EPC STORMWATER REVIEW COMMENTS
IN ORANGE BOXES WITH BLACK TEXT

Cathedral Rock Commons Commercial Grading & Erosion Control Plans El Paso County, Colorado

GEC PLAN
TITLE SHEET

| SHEET: | C1 |

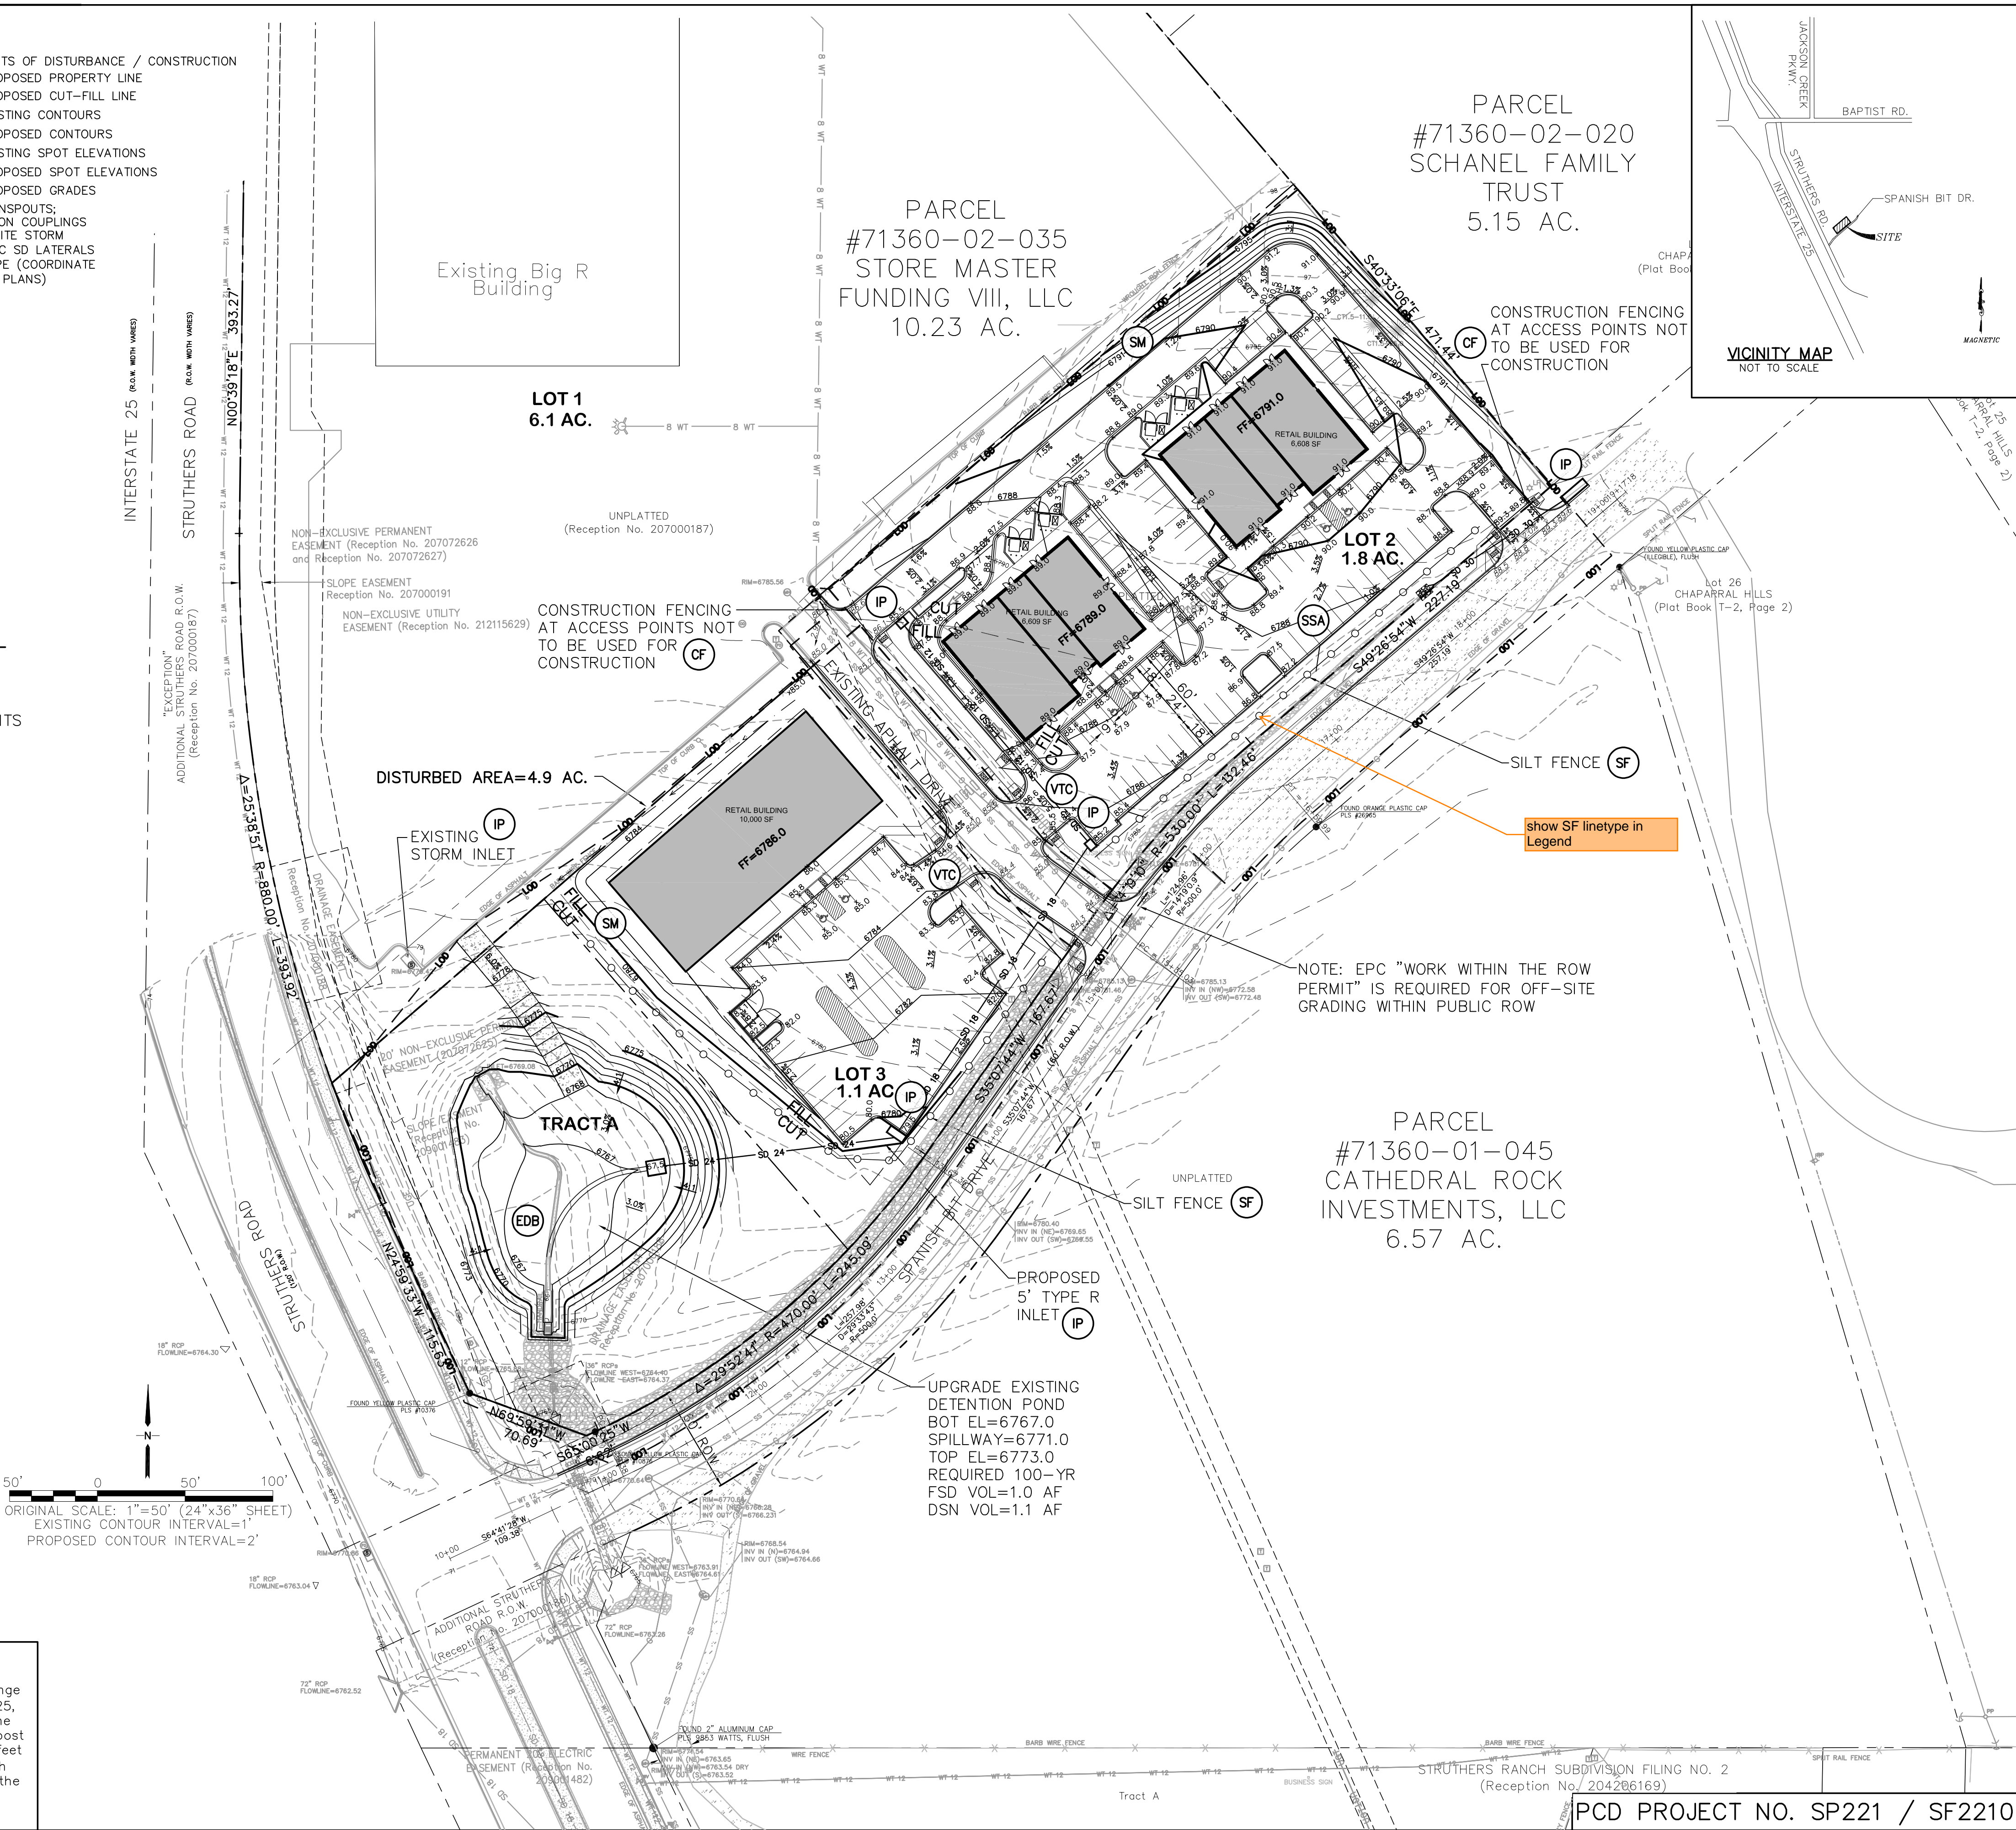
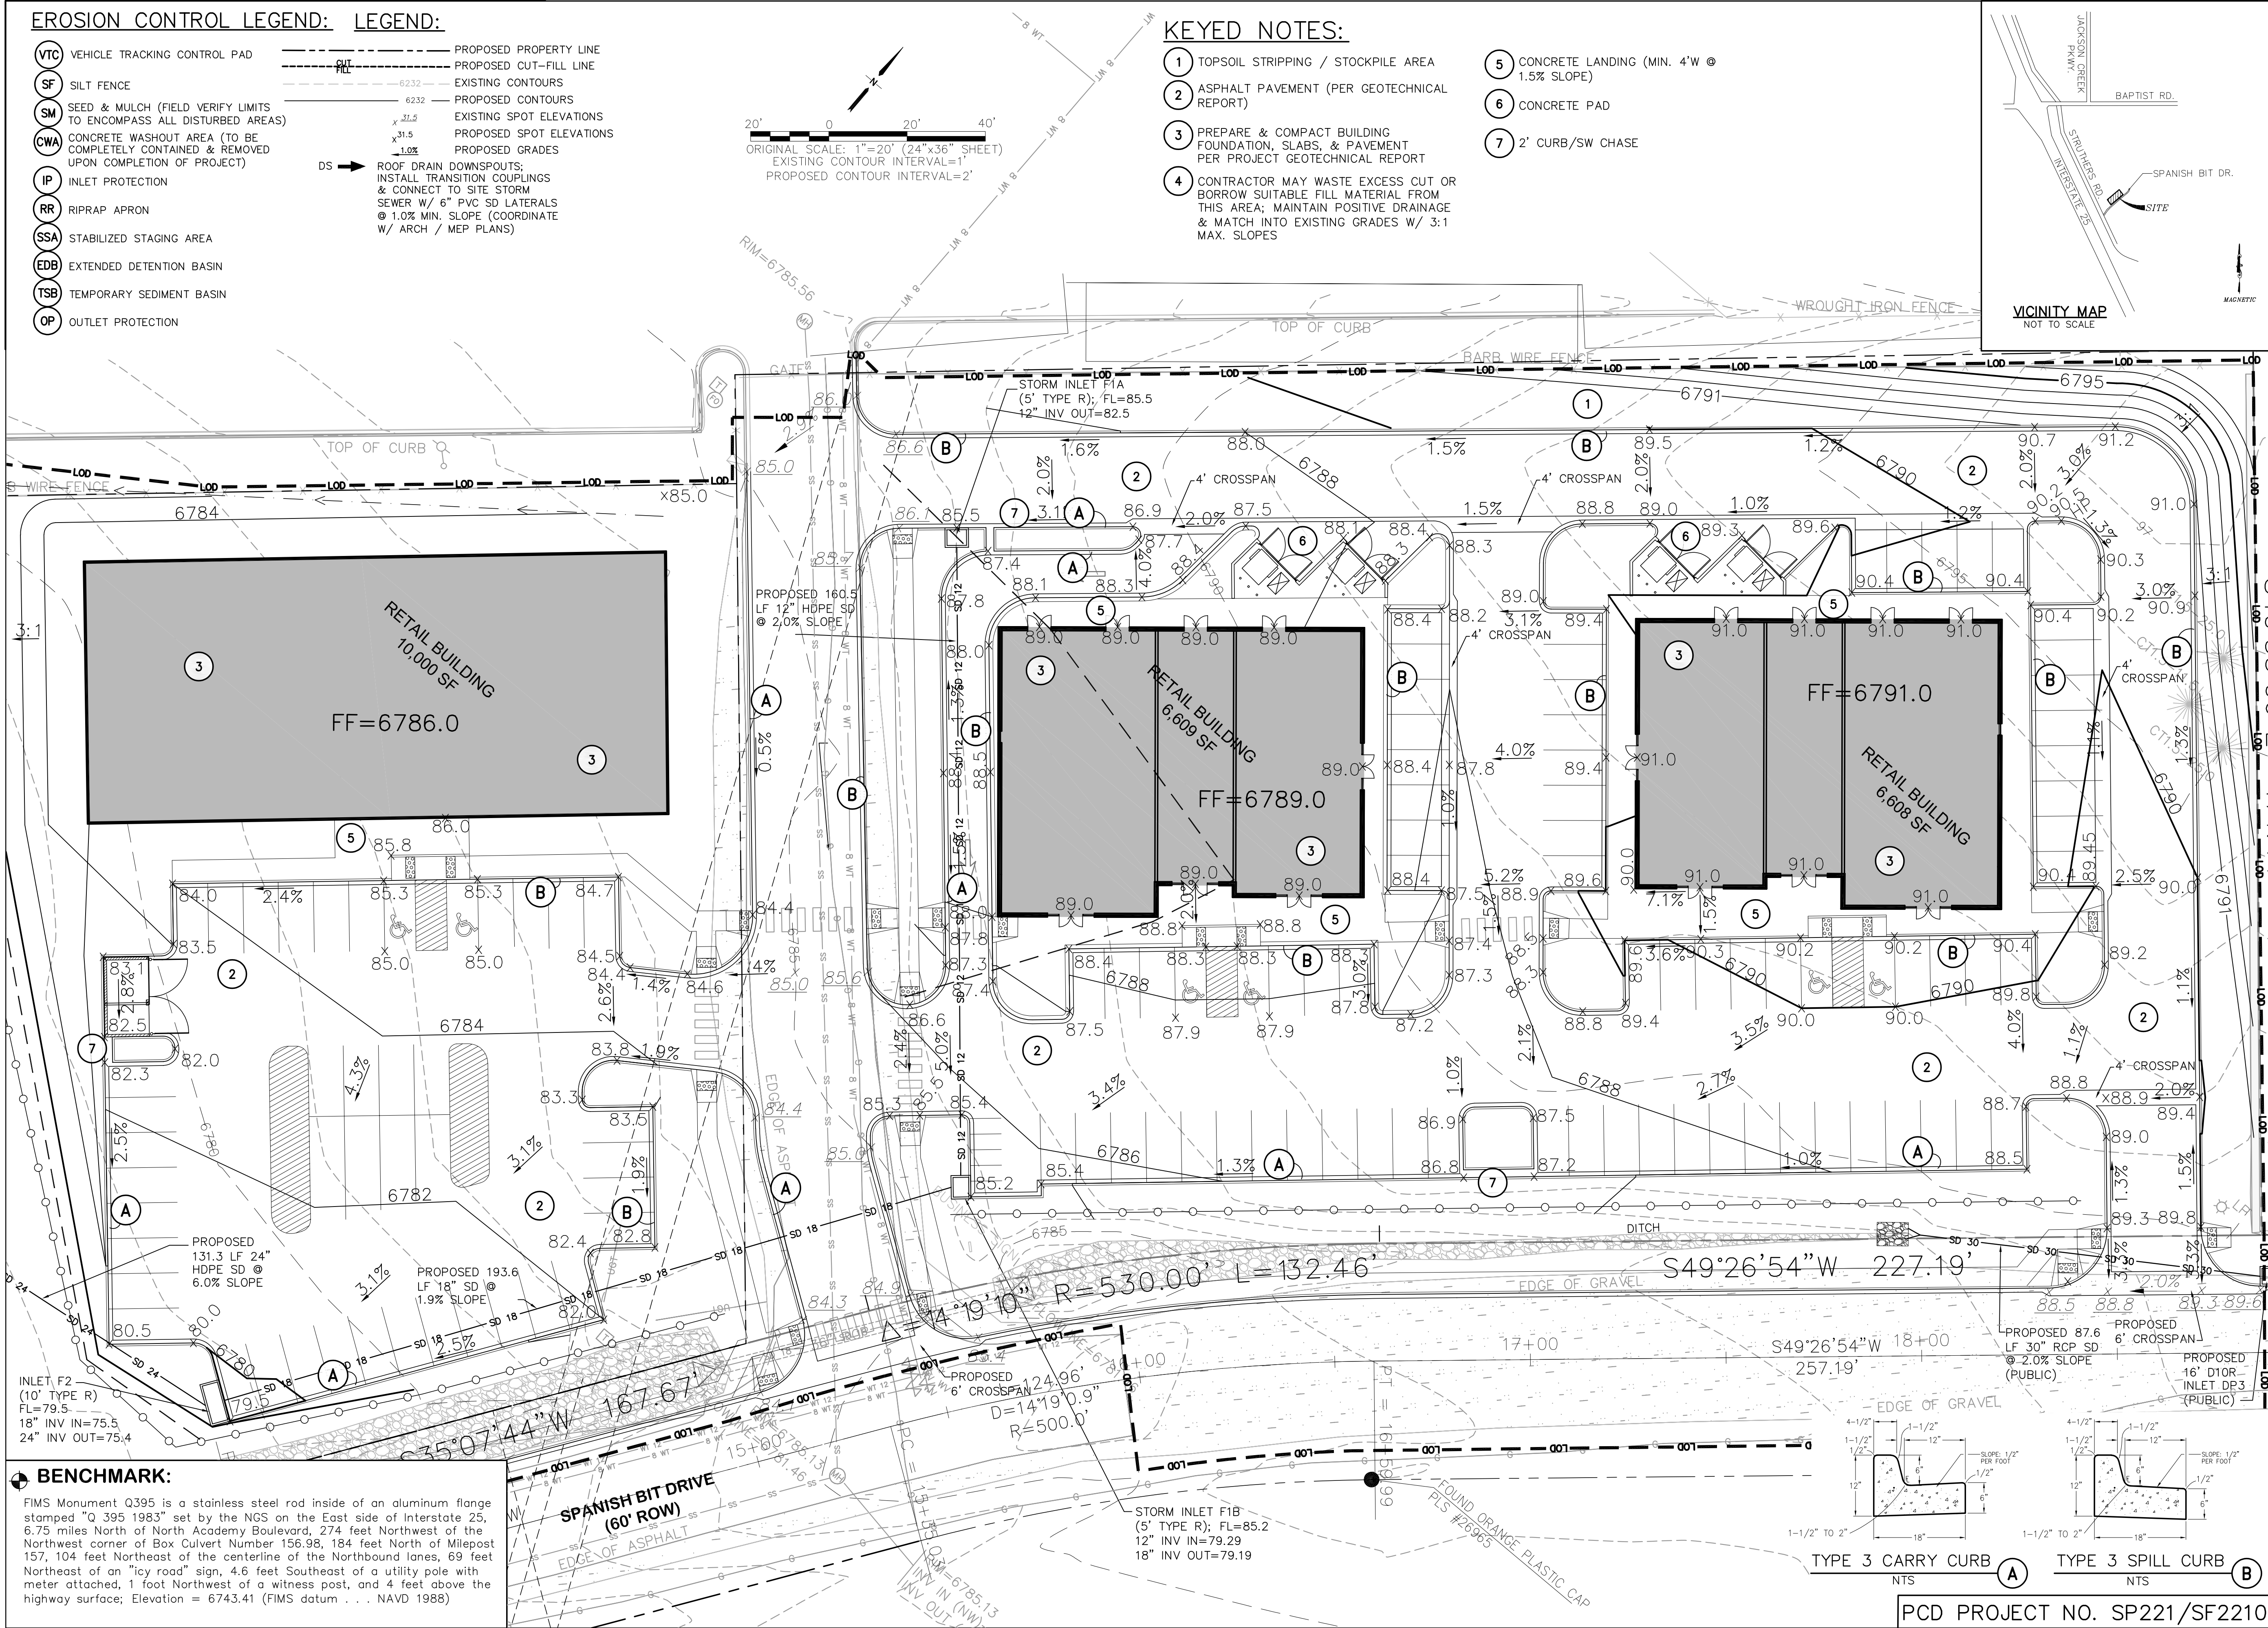
This cut/fill linetype not seen on plans. Show it per Checklist Item "p"

Items H and M. On plans and Legend, label "limits of disturbance" and "construction boundary." If they are the same, change to "limits of construction/disturbance" or otherwise show as separate line types for each on the legend and figure.
